DATE: September 5, 2012
TO: Trevor Thaxter,
Thaxter Company
55 Bell Street
Portland ME 04103
653-8346 Dept. of Building Inspections
City of Portland Maine
SEP 10 2012
PROJECT: Anholt – White Cottage, 66 Shore Road, Cushing Island
RE: Comments from City of Portland Planning & Urban Development Department
BY: Stephen Blatt / Ron Rioux, SBA

The following are responses to comments dated August 24, 2012 from Philip DiPierro of the City Of Portland Planning Division regarding the Anholt – White Cottage.

Brian E. Smith
 REGISTERED LAND SURVEYOR
 BRIAN E. SMITH #1175
 P.L.S. #1175

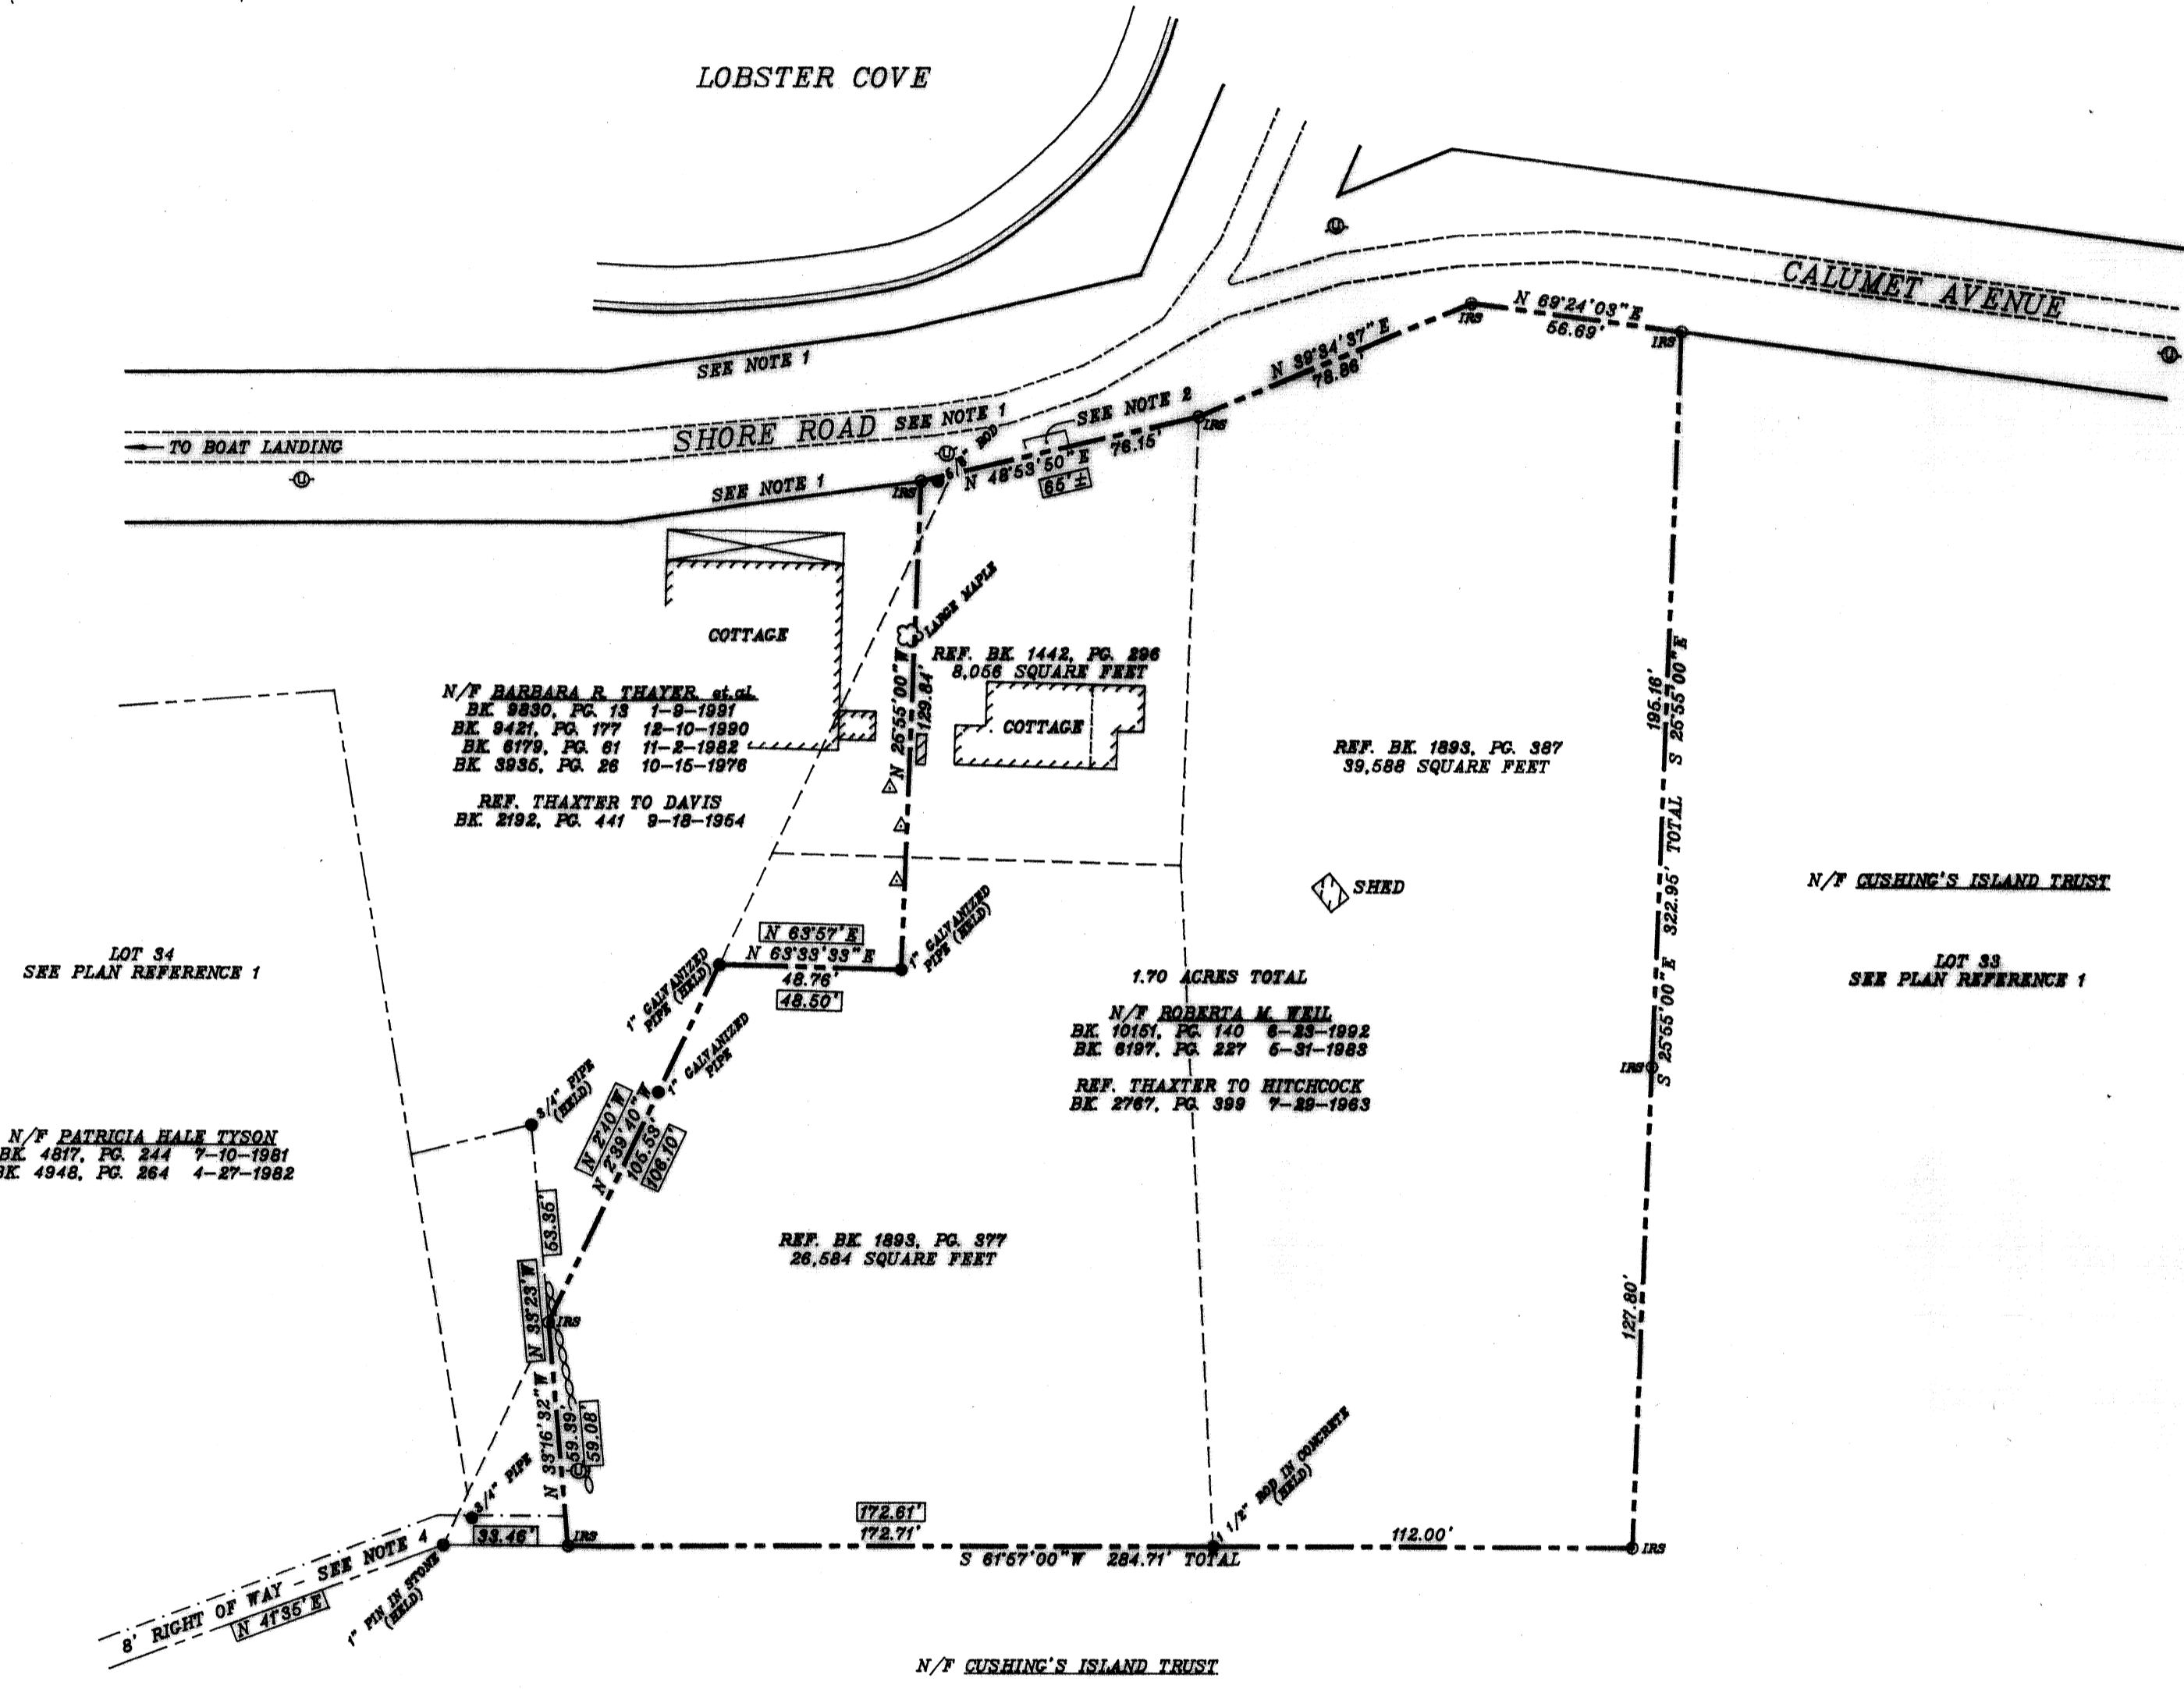
- Boundary Survey plans, based on the State of Maine Professional Licensing Boards legal requirements, shall bear the seal of a Professional Land Surveyor licensed to practice in the State of Maine. Please add the surveyor's seal to the survey.

- **Response: See Standard Boundary Survey for Land of Roberta M. Weil, Shore Road, Cushing's Island, Portland Maine, and Dated August 31, 1993, certified and sealed by Brian Smith Surveying Inc.**

Drawing Title:
Cover, Site, Drawing List,
General Notes

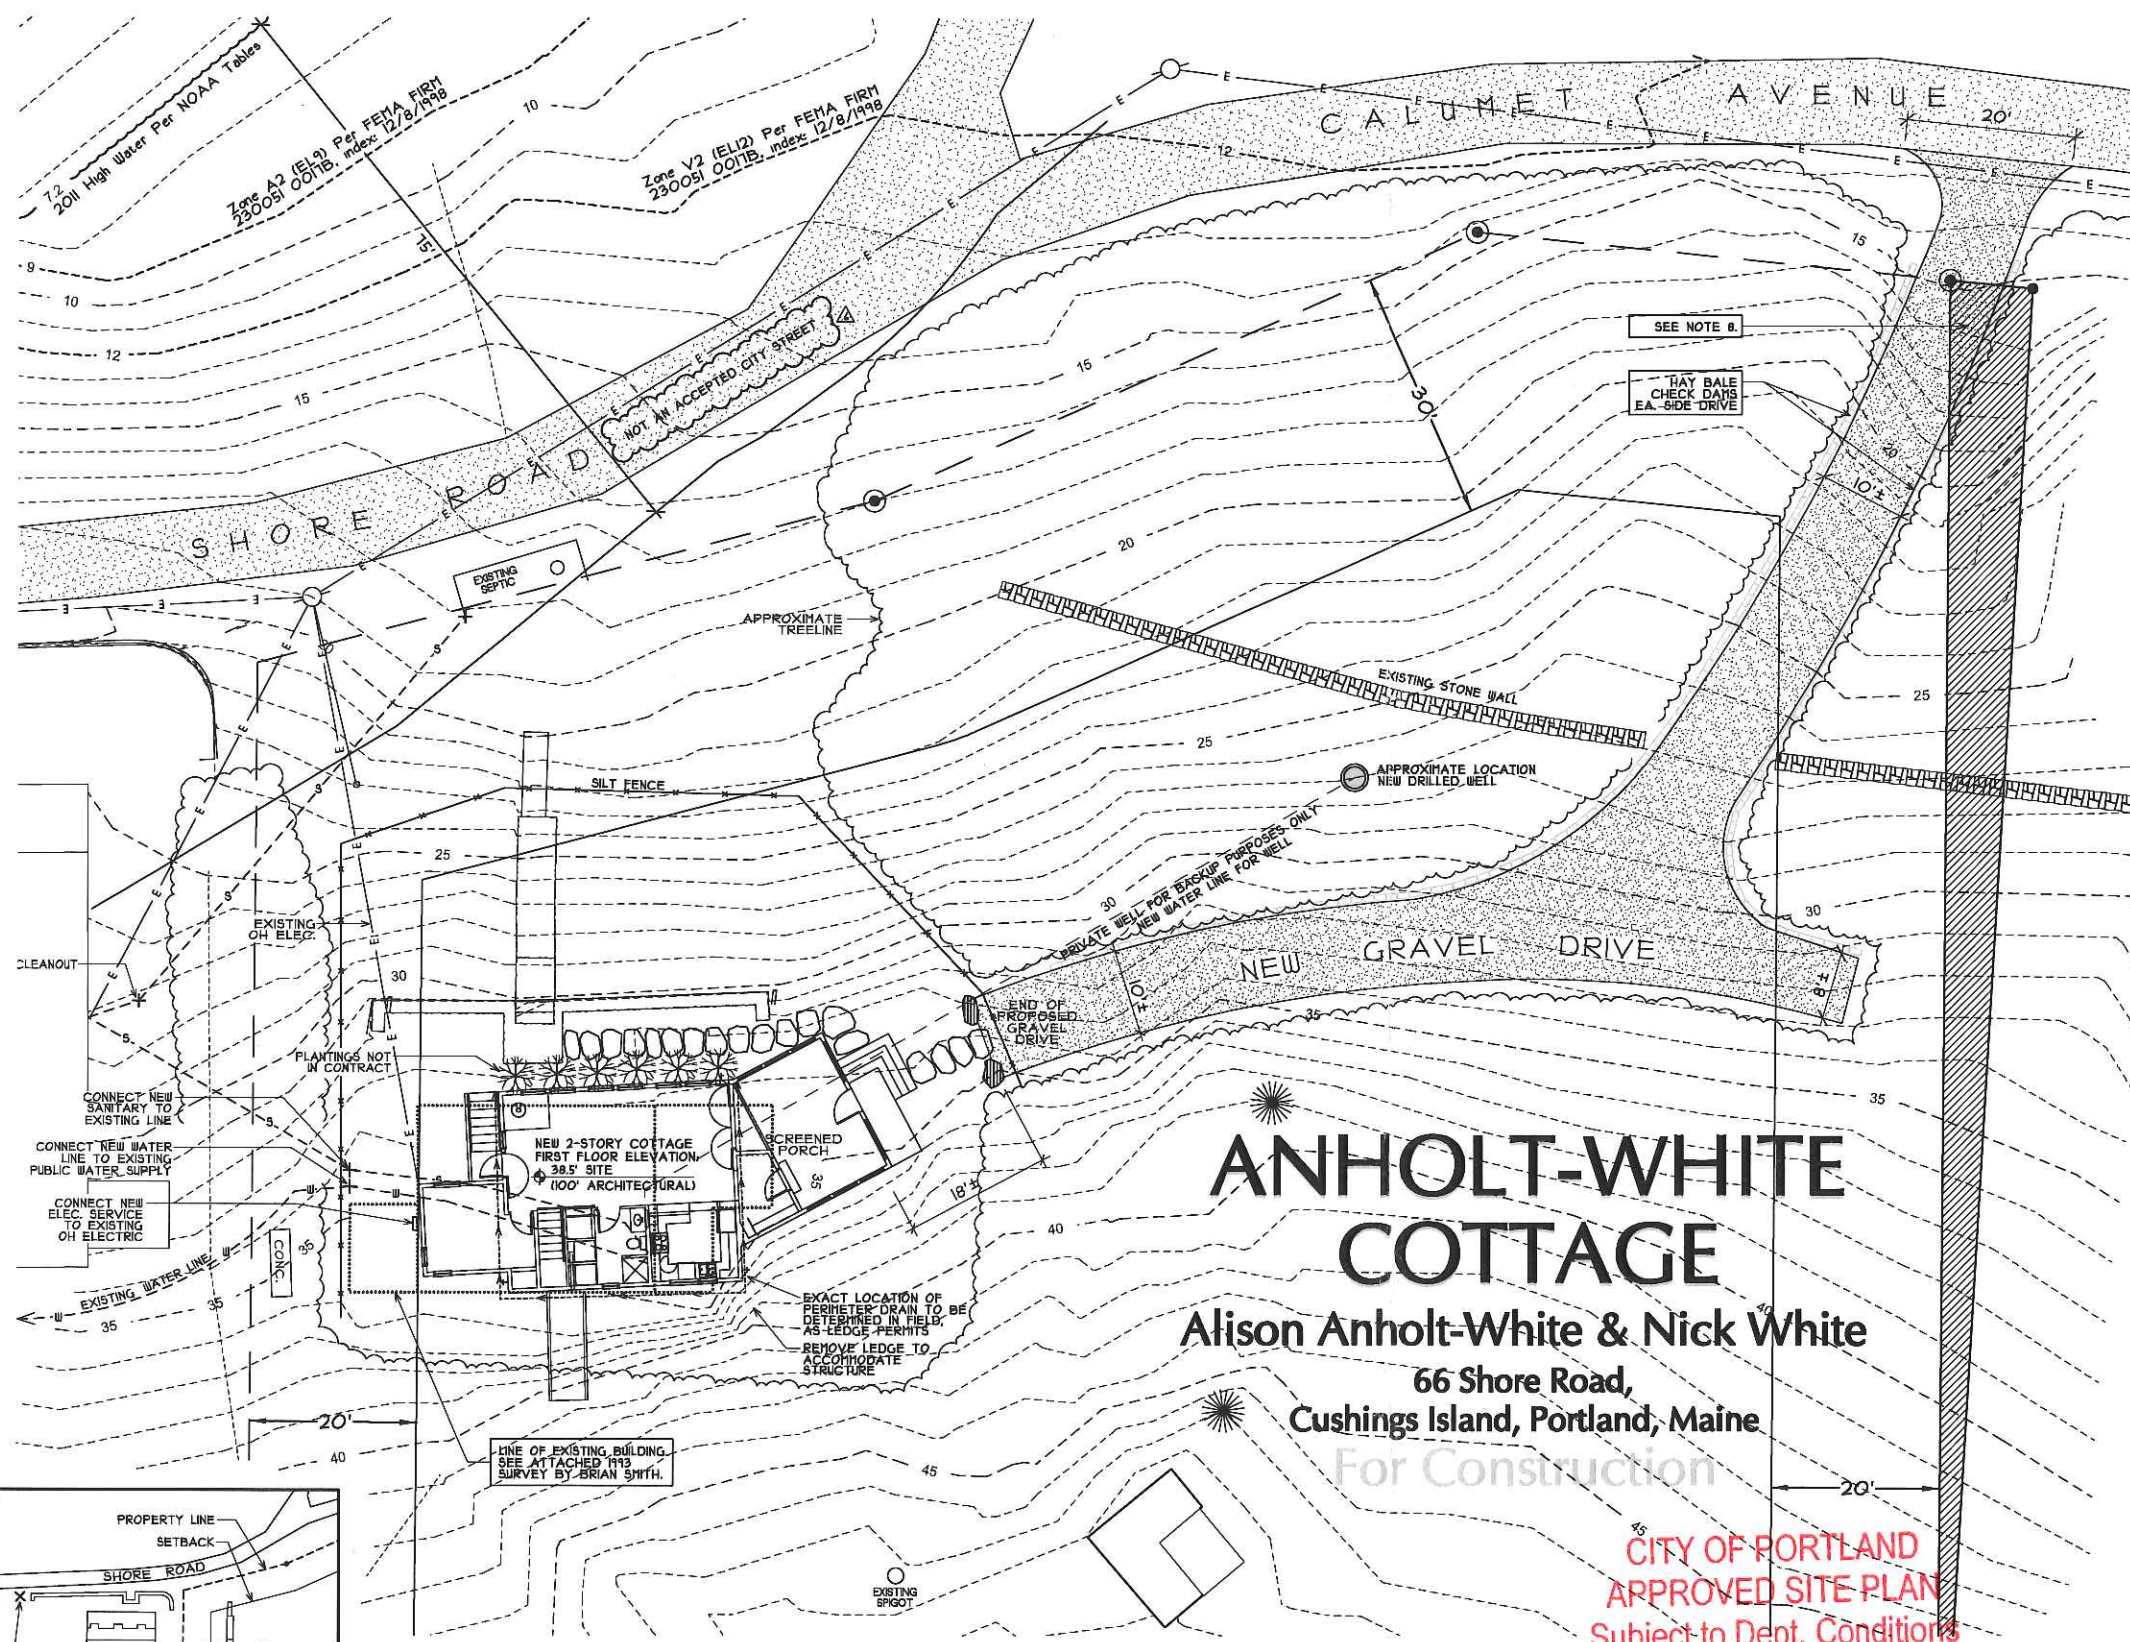
- Please show how you plan to connect the water utility to the well and the sewer utility to the septic system.
 - **Response: The water service will be connected to the existing seasonal Portland Water District service in the street. A well will be added for use during the off season. A note has been added to the site plan.**
 - **The sewer will be connected to the existing sewer line and septic system. A note has been added to the site plan.**

- Please add erosion control plan to include silt fence or erosion control mix around the disturbed areas along both sides and the front of the site.
 - **Response: Silt fence has been added to the site plan.**

- Please show the location, area in square feet, and the limits of the proposed site disturbance on the site plan,
 - **Response: The area to be disturbed is limited to the foot print of the existing cottage and the new cottage that mostly overlays the existing. The area of disturbance for the cottage is approximately 1500 s.f.**
 - **The area of disturbance for the driveway is approximately 2700 s.f.**
 - **These areas have been added to the site plan.**

- Please reduce the width of the driveway opening at the street line. The maximum allowable driveway width at the curb line is 24 feet per City of Portland Technical Manual.
 - **Response: The width of the curb opening at the street line has been reduced to 20 feet and shown on the site plan.**

- Zoning Requirements:
 - Please submit a revised site plan that includes the following information:
 - The site plan needs to show the 75' setback and the 250' set back from high tide for the Shoreland Zone.

- The existing cottage does not meet the 20' setback on the right side of the property. There is no evidence that the existing footprint is legal. If the owner can't show that the footprint was permitted, the new structure must be relocated to meet the 20' side setback.

- **Response: Records confirming the legality of the existing foot print could not be found. The cottage has been moved to the east to conform to the 20 foot side setback.**
